Jean Fraser - Re: 79 Walnut Street Development

From: Kathleen McKeon <kmckeon@maine.rr.com>
To: Jean Fraser <JF@portlandmaine.gov>
Date: 12/12/2013 6:31 AM
Subject: Re: 79 Walnut Street Development

DRAWING NO.
C-10

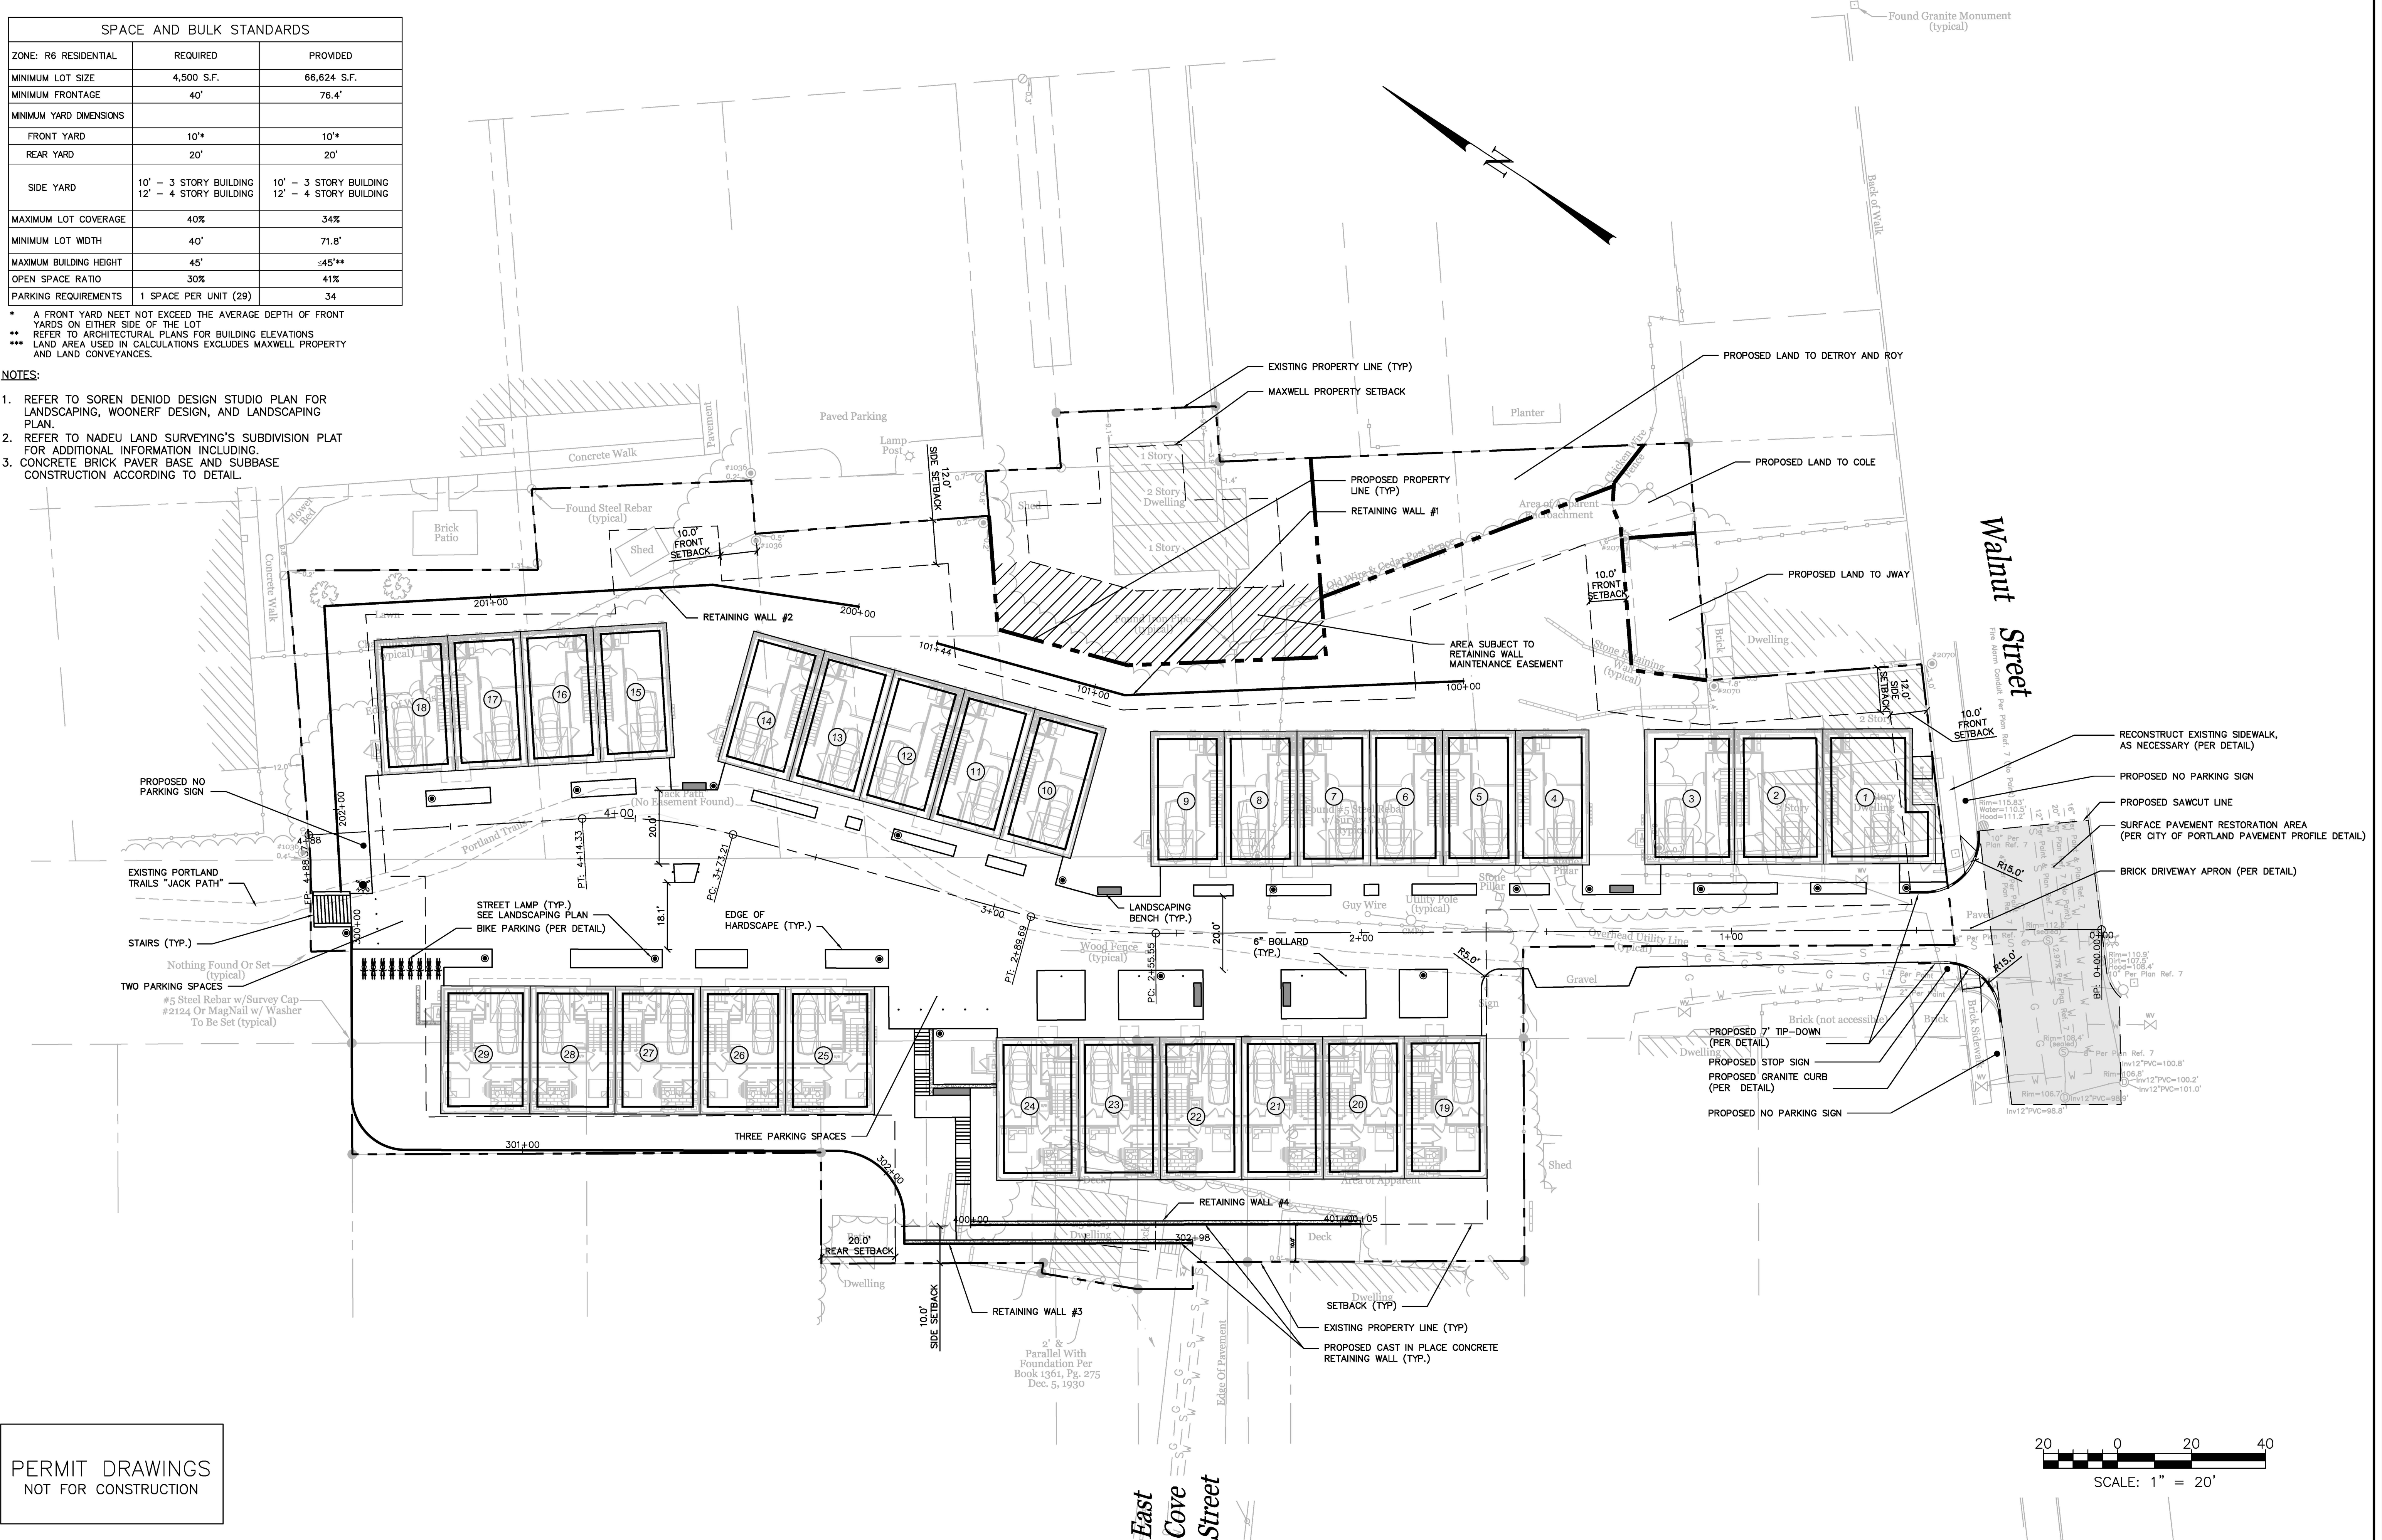
Parking is limited to only five spaces at the far end of the project and is likely to overflow on to Walnut and Sheridan Street. I did not see any handicap parking plans or any type of parking study. It does not seem possible that this project meets city requirements for parking given the number of residents and visitors. The planning board should request a parking analysis per city ordinance 14:526 (4)(a)(i). Additionally, the increase in traffic flow on surrounding streets does potentially affect public safety and a crosswalk should be considered (as recommended in the Traffic analysis) and per code 14:526 (1)(a). There are two busy intersections on Walnut at Washington and North Street that are entrance and exit points for many commuters, children walk to school and people drive fast on Walnut.

The site plan appears to have inadequate preparation for snow removal, 14:526 D (i)(ii). Snow accumulation can be extreme in Maine and the narrow street design will make plowing difficult if there is limited area to put the snow due to parking and Jack Path stairway entrances. The topic of public access of the Jack Path only during daylight hours should also be discussed and clarified. Public access to this path should be permanent, not dependent on the developer or residents of the new project. We must obtain legal agreement that public access will not be denied to any area of this development prior to approval by the planning board.
